**KIRKLEES METROPOLITAN COUNCIL
INVESTMENT & REGENERATION SERVICE**

DELEGATED DECISION TO DETERMINE PLANNING APPLICATIONS

Reference No:	2024/62/91954/E
Site Address:	13, Westgate, Cleckheaton, BD19 5ET
Description:	Change of use of basement into self contained flat and erection of dormer windows at second floor
Recommending Officer:	Edward Cheseldine

DECISION - REFUSED

PROPOSED FRONT ELEVATION

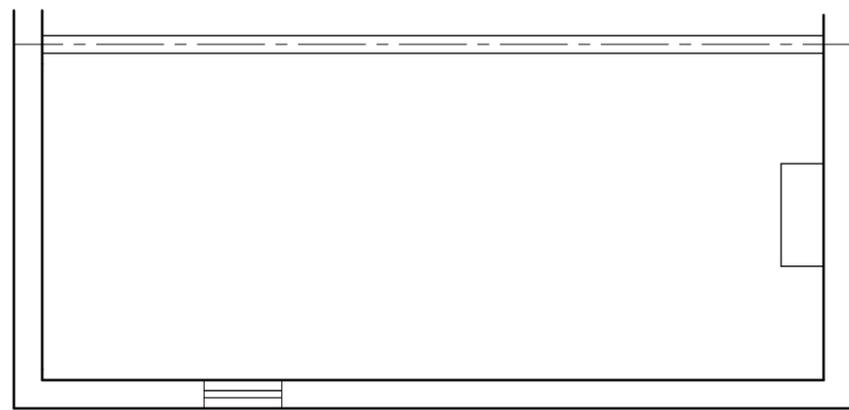
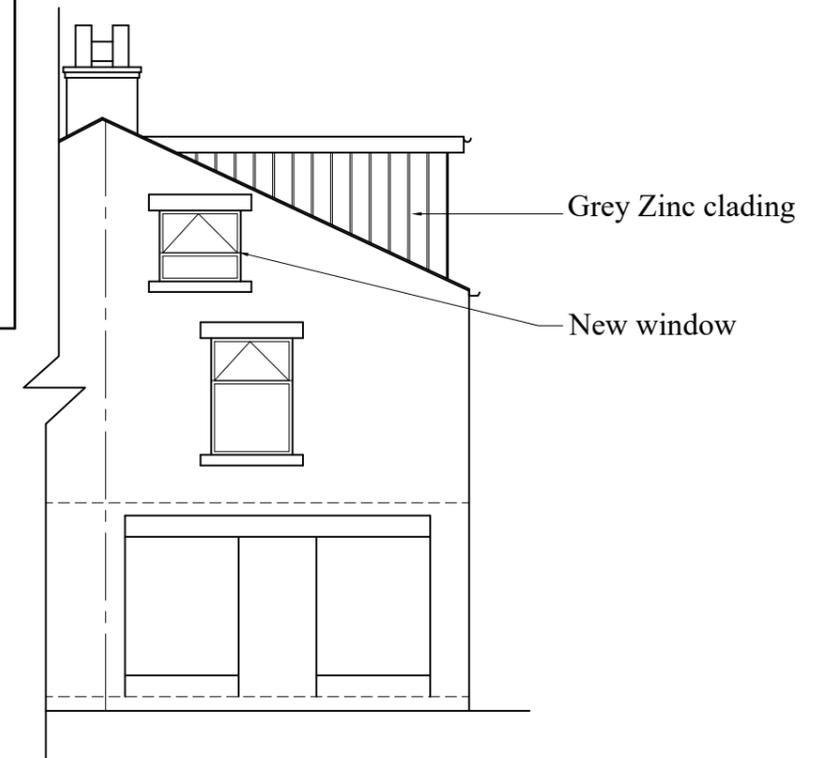
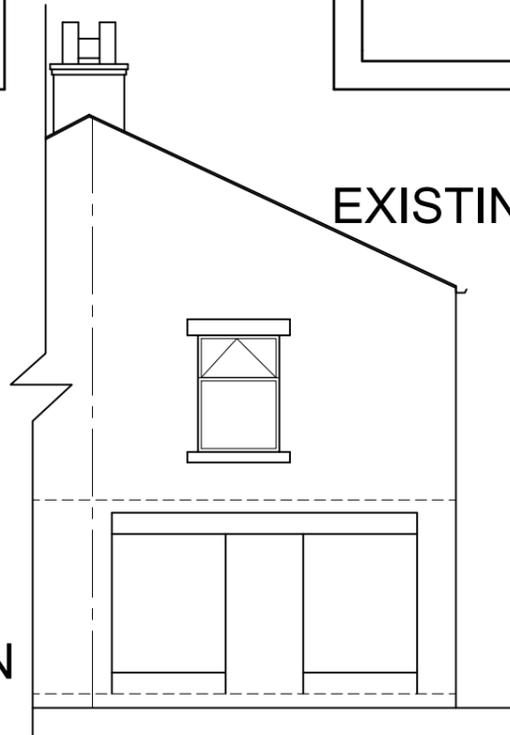
The building hosts a prominent position on a main road entering Cleckheaton. Westgate is a busy single-carriage A road. The roof plane is highly visible to traffic and user of the footpath when travelling eastbound on Westgate. In addition, the prevailing street scene represents a traditional setting, formed through the sandstone buildings that line Westgate, as well as the historic viaduct. The dormers fail to assimilate with the traditional setting of the streetscene. Given their scale and flat roof form, they would form a prominent, modern addition to the area that would appear stark within the prevailing landscape.

The dormers will have a ridgeline of ~4.50m and a width of ~4.30m/~4.65m. The proposed dormers are considerably large in scale, a ~4.50m ridgeline projection on the front elevation would appear as a large addition to the present roof form. The zinc cladding would A significant proportion of the original roof would be covered by the dormers which neither appear modest, or in keeping with the traditional design of the building.

The large structures would therefore have a top-heavy appearance that would be overly dominate to the original building and street scene, being contrary to the thrust of the Kirklees House Extensions & Alterations Supplementary Planning Document paragraph 5.24.

Relevant to the formation of a new dwelling, is that habitable rooms are served with sufficient light and outlooks. The new dwelling would be formed at a basement level. There is a gentle gradient on Old Robin that slopes gently from north to south, revealing a section of the basement level. Following an Officer site visit, it has been concluded that the basement level openings

would be wholly unacceptable to provide amenity for future occupiers of the basement flat. The elevation drawings indicate ~0.18m of the window to the left of the elevation would be present, and ~0.67m of the window to the right would be present. These windows are the sole outlooks for the dwelling. For the purposes of modern habitable standards, the openings would not provide sufficient natural light or an outlook that is satisfactory, therefore the new dwelling fails to accord with Policy LP24 b) of the Kirklees Local Plan in relation to future occupants.

PROPOSED BASEMENT FLOOR

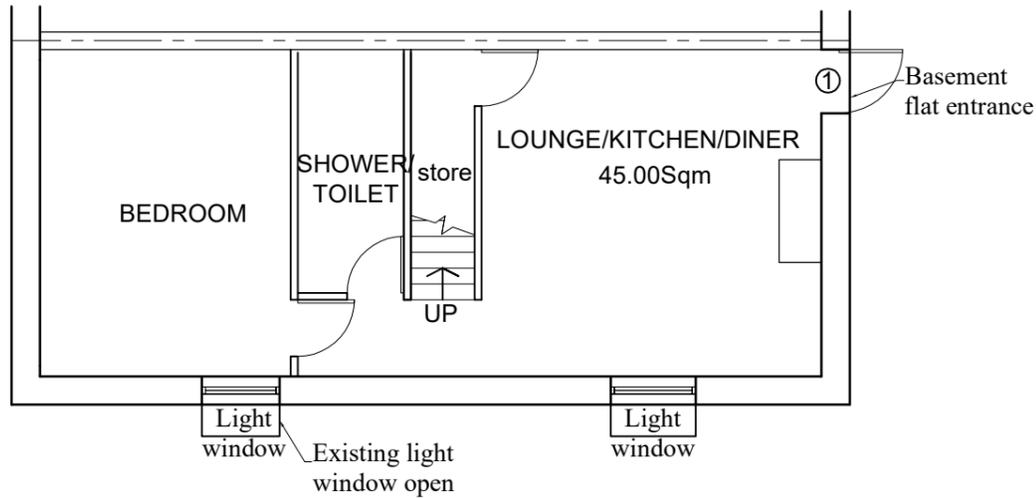
The floor plans indicate the dwelling will have one-bedroom, with living accommodation and a shower room. Single bedroom accommodation for adults should include two bed spaces for occupancy. NDSS recommend a one-bedroom dwelling, over 1 storey should have internal living space of 50m². The internal floorspace of the dwelling would be 45m², with a bedroom size of 16.20m². Whilst the floor space of the bedroom does meet the requirements of NDSS, the internal living space of the flat is substandard to meet the criteria for two bedspaces. Once furniture, a kitchen and possessions are added to the flat, the living space will not be a suitable size to host two adults.

The proposed development therefore fails to accord with Principle 16 of the Kirklees Housebuilders Design Guide SPD in terms of internal floor space which has adopted the Nationally Described Space Standards, Local Plan Policy LP24(b) and Chapter 12 of the National Planning Policy Framework
